Subject: RE: A18237C. Kings Beach Hotel (P/83/18/DOC)

Laura Gibbons, MEng, GMICE
Engineer (Drainage & Coastal)

Note:
Proposed levels TBC by architect prior to finalisation of design.

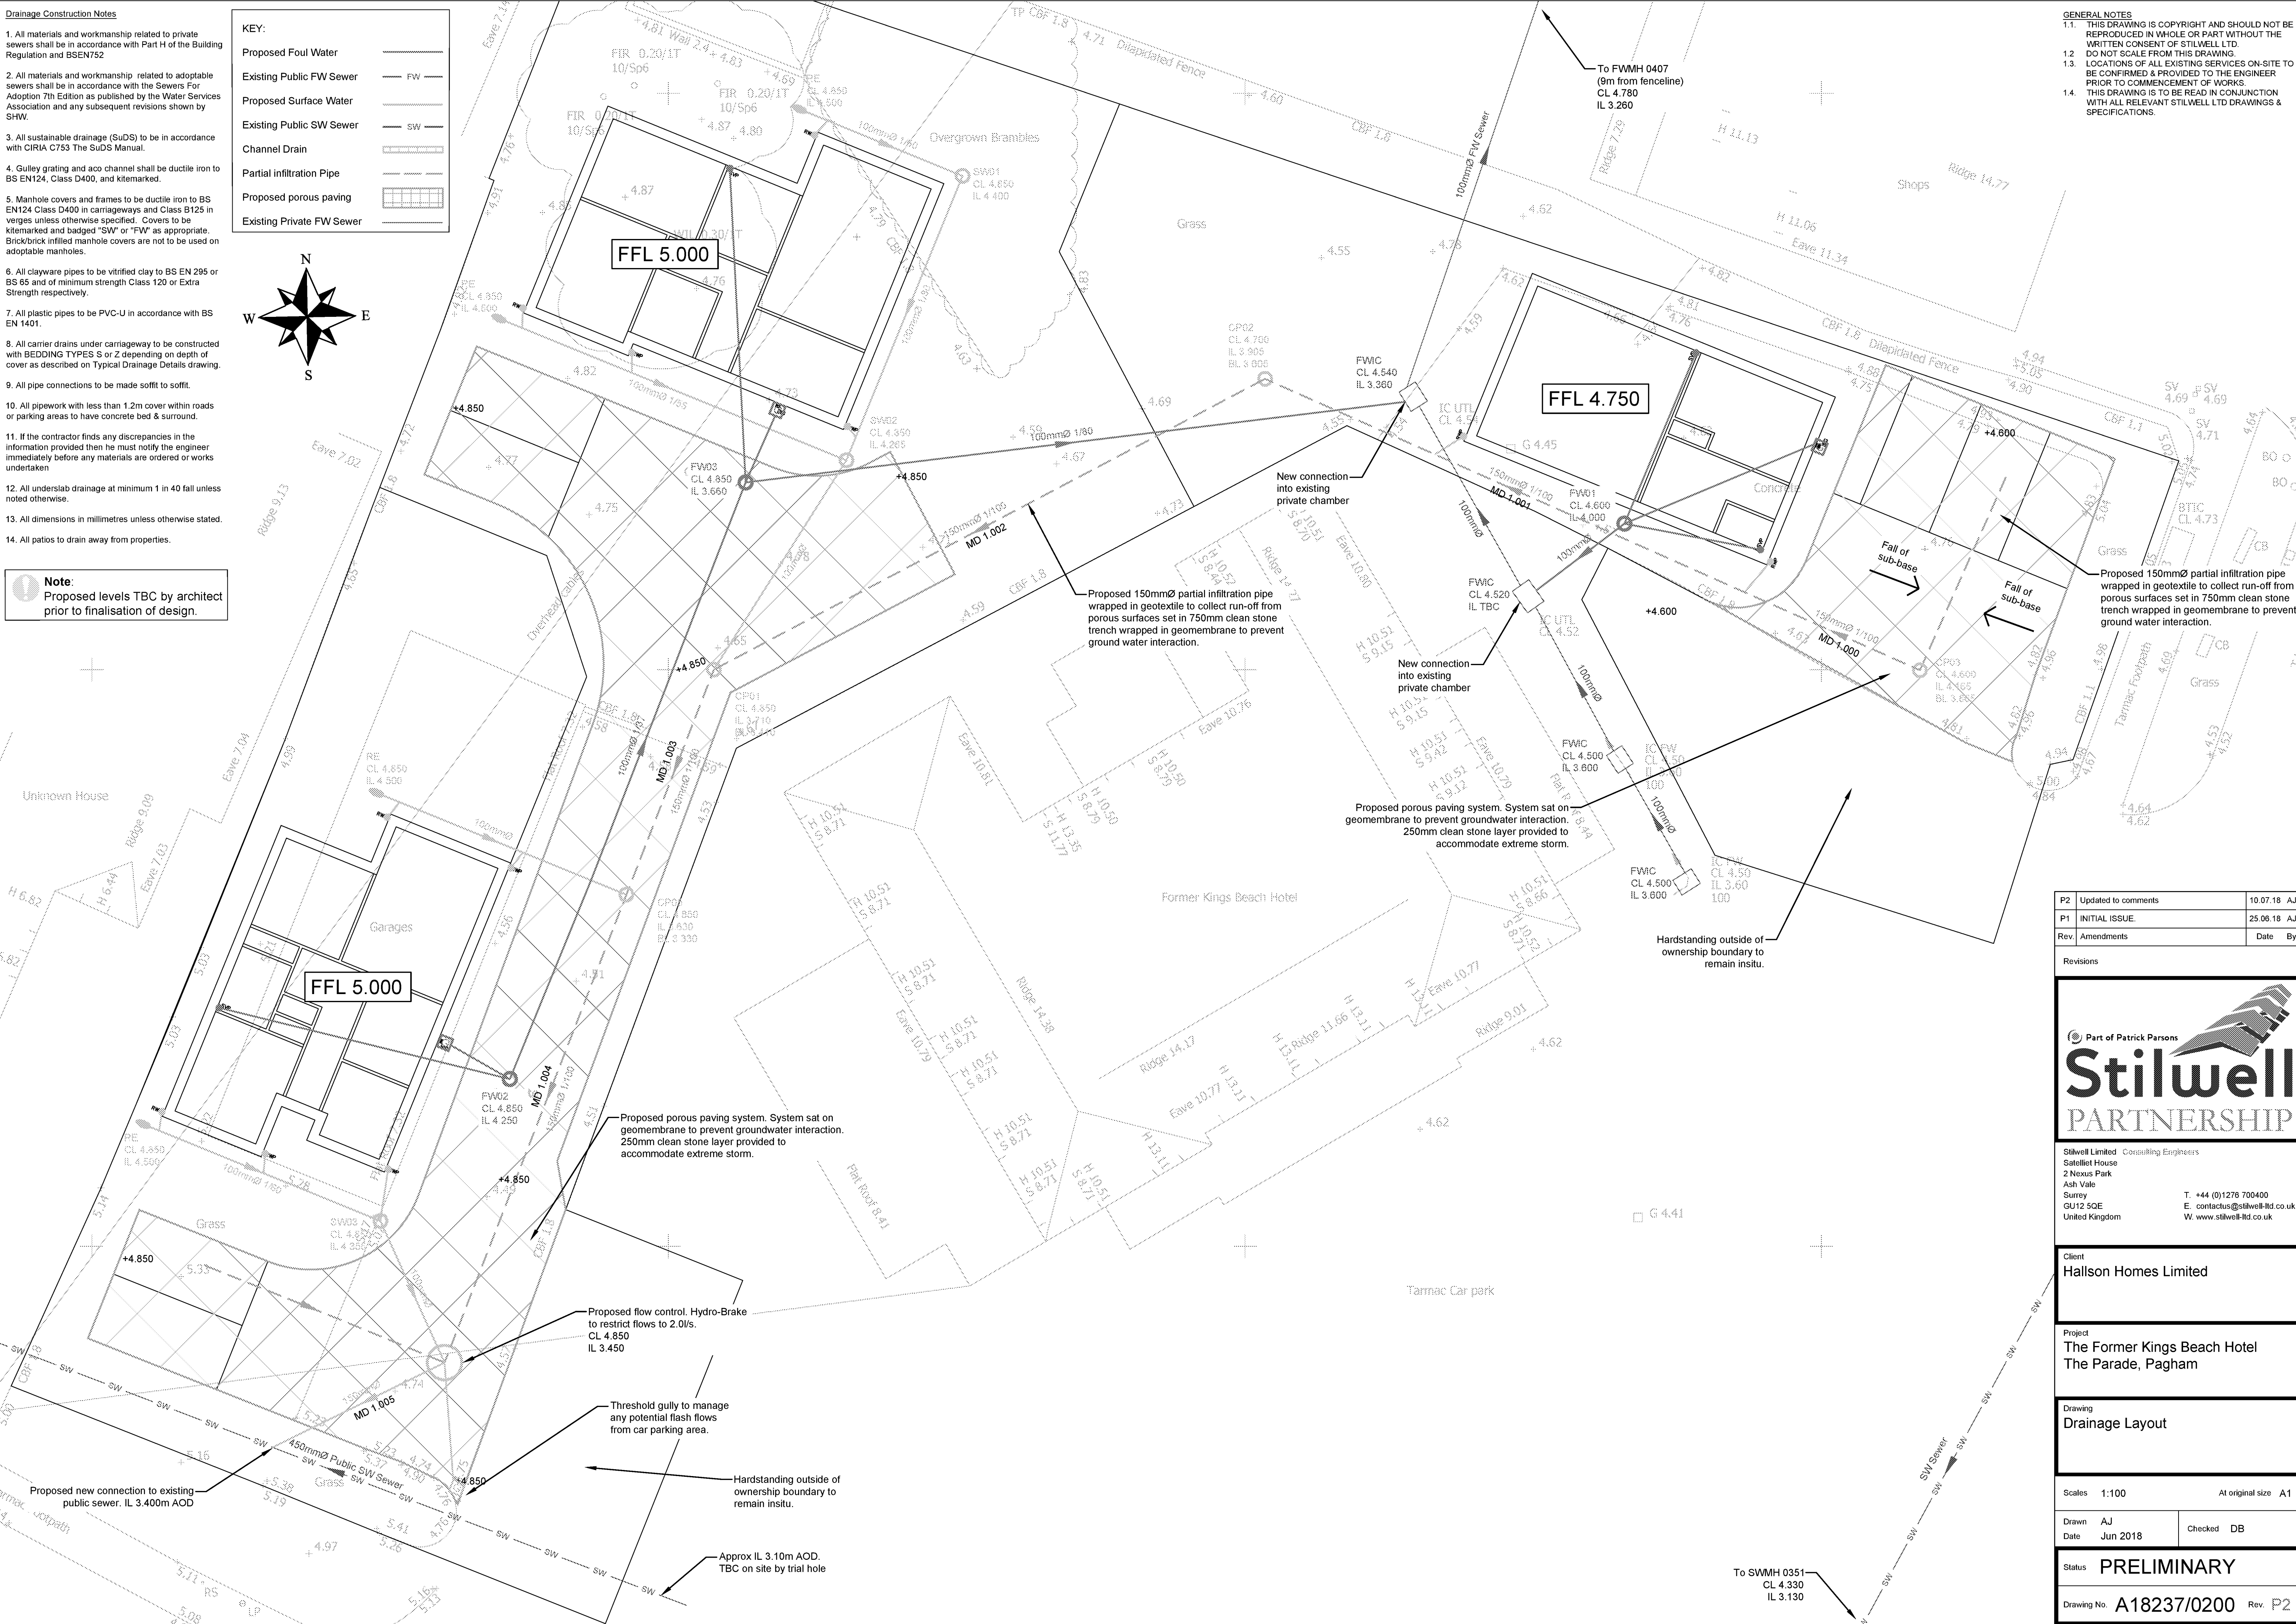
I do need to see the finish and formation levels specified on the layout plan too.

The calculations do not stipulate the capped depth of stone you state, you have only got invert and cover depths for the storage features. The difference between these is not equal to the depth of stone you stipulate, nor is there any other differentiation between void ratios of the various layers above the stone.

The stone depth required needs to equal or exceed the maximum water depth modelled. Either you model the invert and cover depths so that the difference is equal to the stone you propose, or you model total formation depths and take the maximum water depth calculated as the depth of stone required.

As a further check (which may help demonstrate my point) please ensure the free volume within the stone sub base is equal to or greater than the maximum water volume. If as you state in the eastern catchment you have 250mm of stone, free volume is $10 \times 9 \times 0.3 \times 0.25 = 6.75 \text{ m}^3$, this is less than the maximum volume of water of 10.4 m^3 .

Therefore, the depth of stone needs to be increased.

The drainage layout submitted doesn't show the permeable paving extents. I don't know if the layer was just switched off or what. However, please ensure extents are shown and that the paving is labelled up with finish and formation level.

The calculations also demonstrate that 390mm stone is required in the west, and 460mm in the east. Please update drawings accordingly.

No problem. I used an arbitrary level on the calculations just to get the design done which may have caused some confusion. I have now updated to the correct levels (attached).

Also formation level and cover level shown on the drawing for completeness. I have increased the eastern side to 350mm, the calcs had a typo in which accounts for the error you noted. Many thanks and apologies for that.

Please find attached the updated pack. The system requires 250mm stone in the east side and 350mm stone in the west.
